Date: 23-Jun-2026
Our Ref: 2026/91192

**Application for a non-material amendment following a grant of planning permission,
Town and Country Planning Act 1990**

Non material amendment to previous permission 2024/91998 for erection of special educational needs and disabilities school (Use Class F1), comprising educational buildings, roof mounted photo-voltaic panels, sensory garden spaces, multi-use games areas, landscaping, hardstanding areas, carparking, access with secure fencing and associated ancillary development
Former, Almondbury High School, Fernside Avenue, Huddersfield, HD5 8PQ
Application Number: 2026/91192

Proposed Plan
(Scale 1:500)

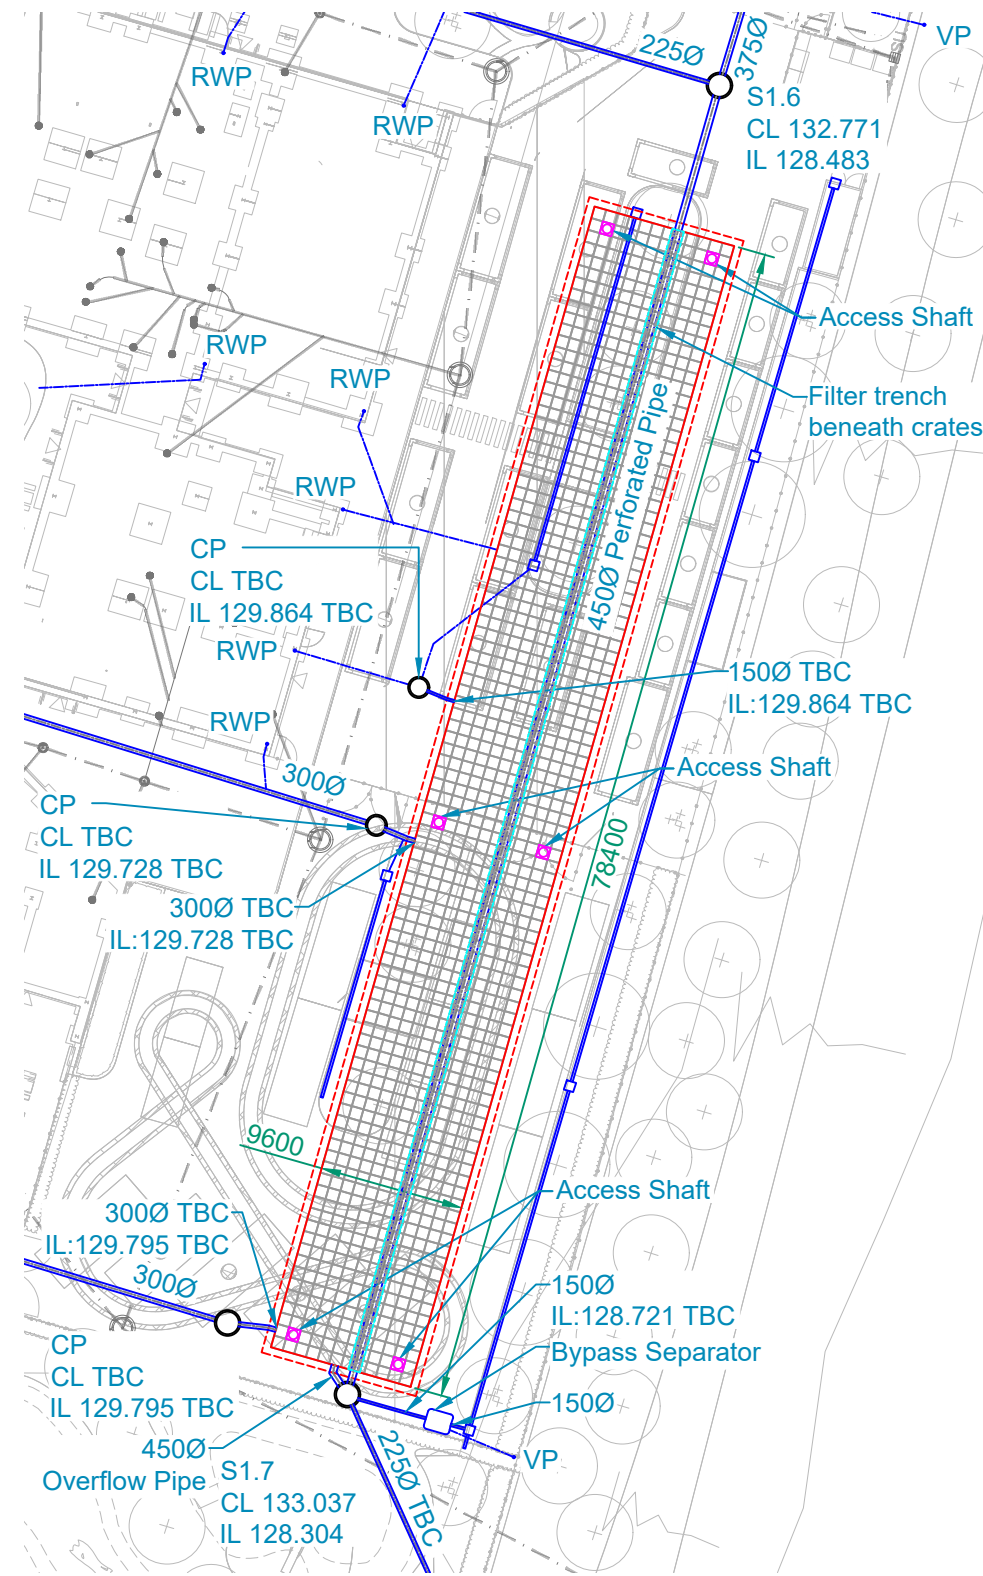
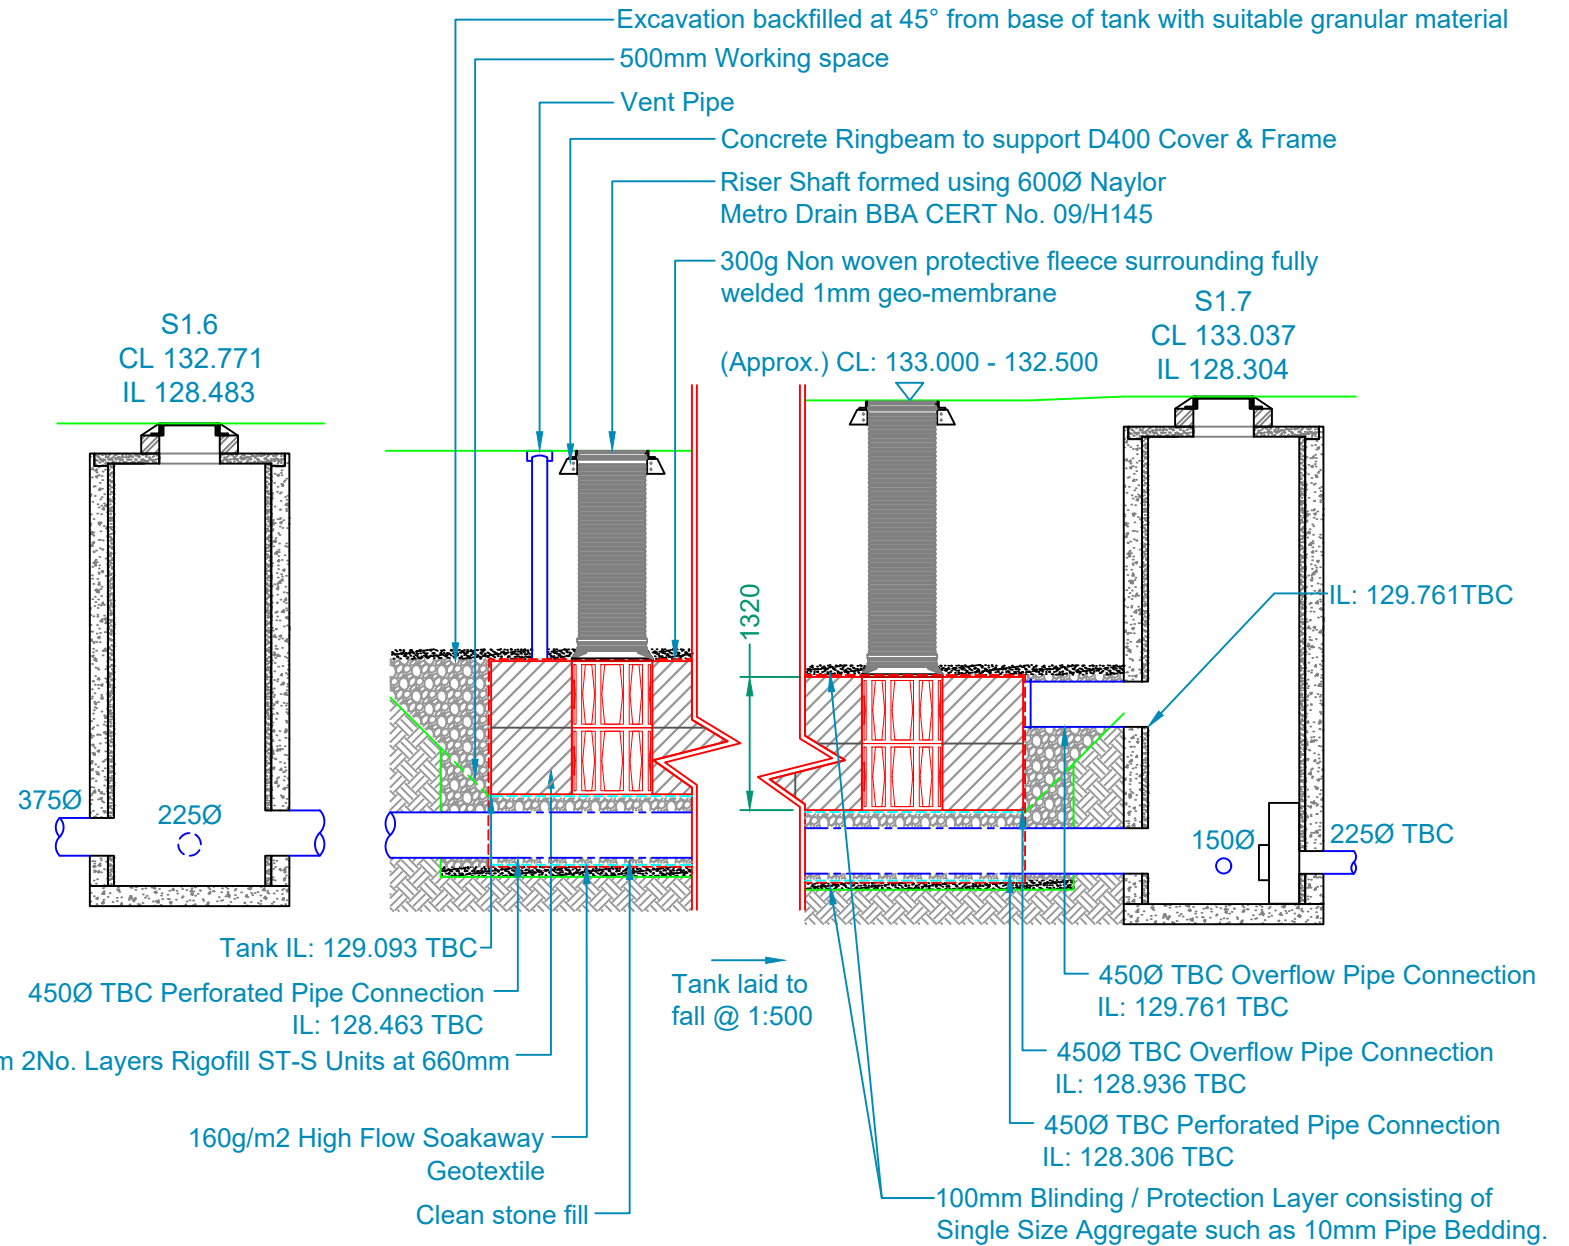
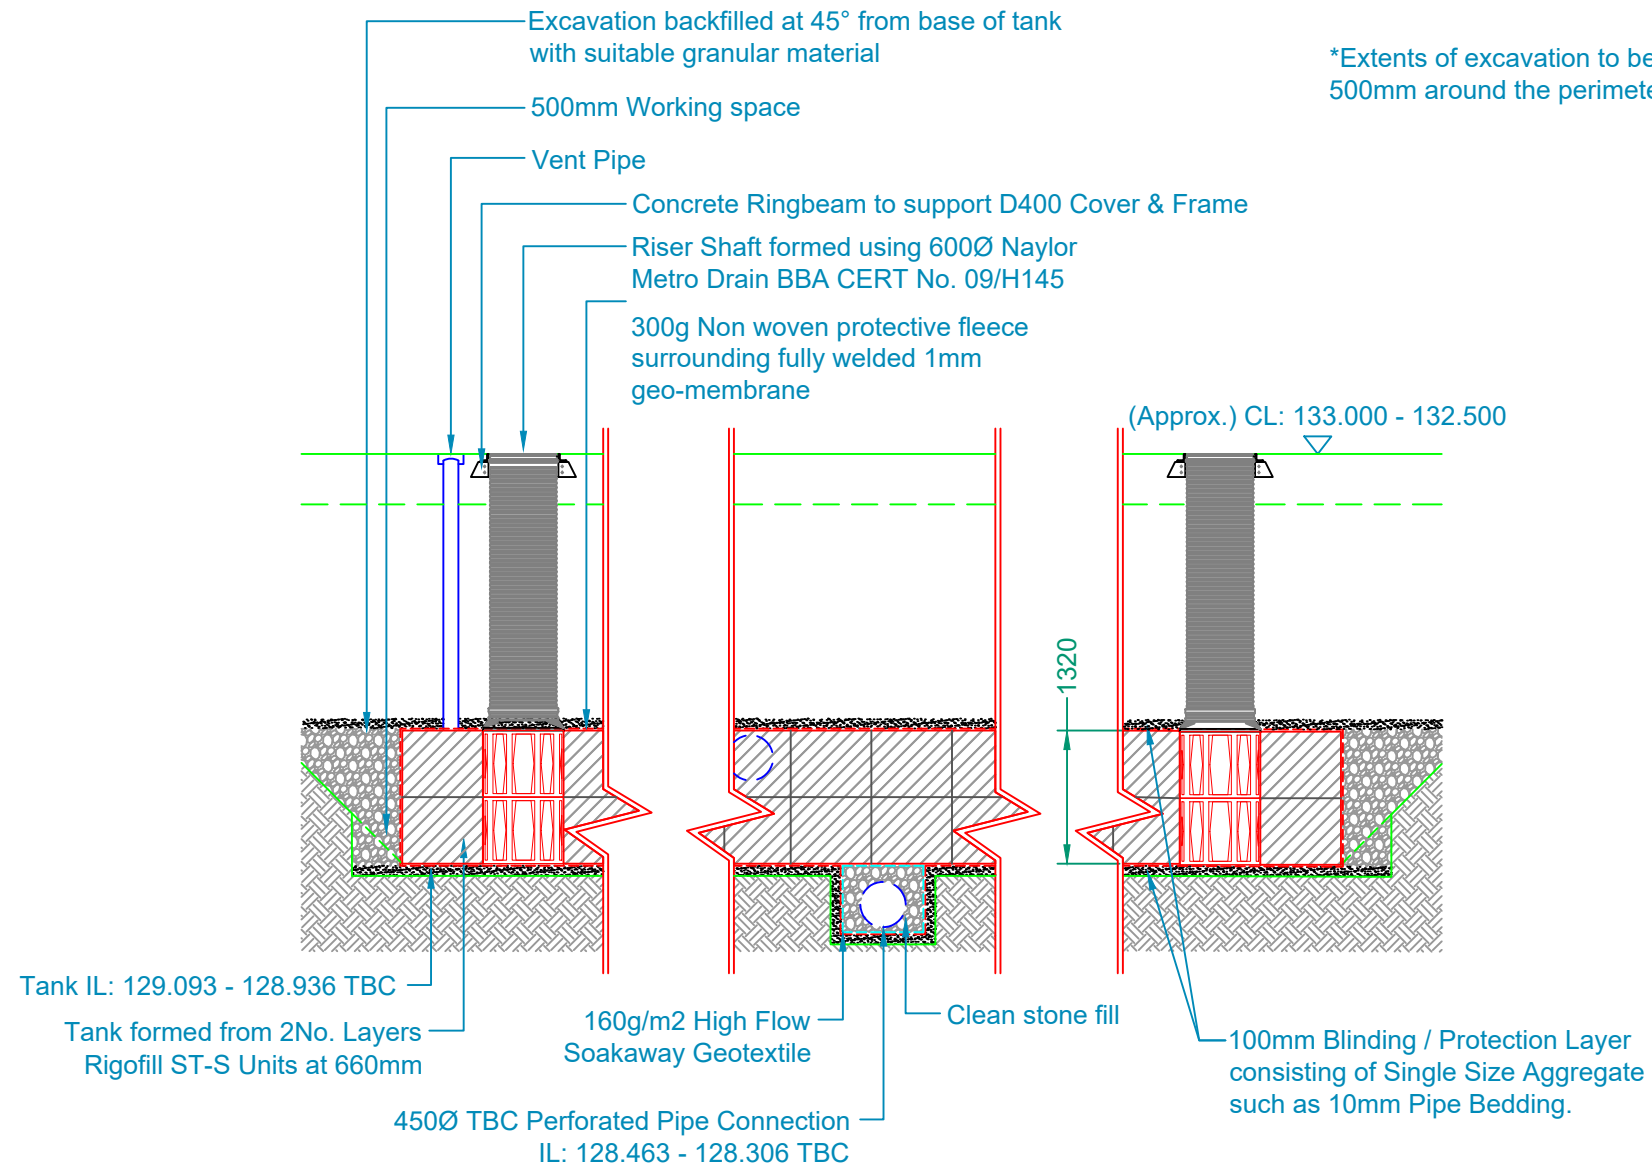
- It is proposed to amend the drainage attenuation system by replacing the previously indicated Tubosider system with a modular attenuation system.

22. The development shall be carried out in accordance with the details shown on the submitted plans, "Drainage Planning Technical Note" Drawing No. NWSC-HEX-XX-XX-TN-C-0001-V01, dated 28/04/2026", unless otherwise agreed in writing with the Local Planning Authority.
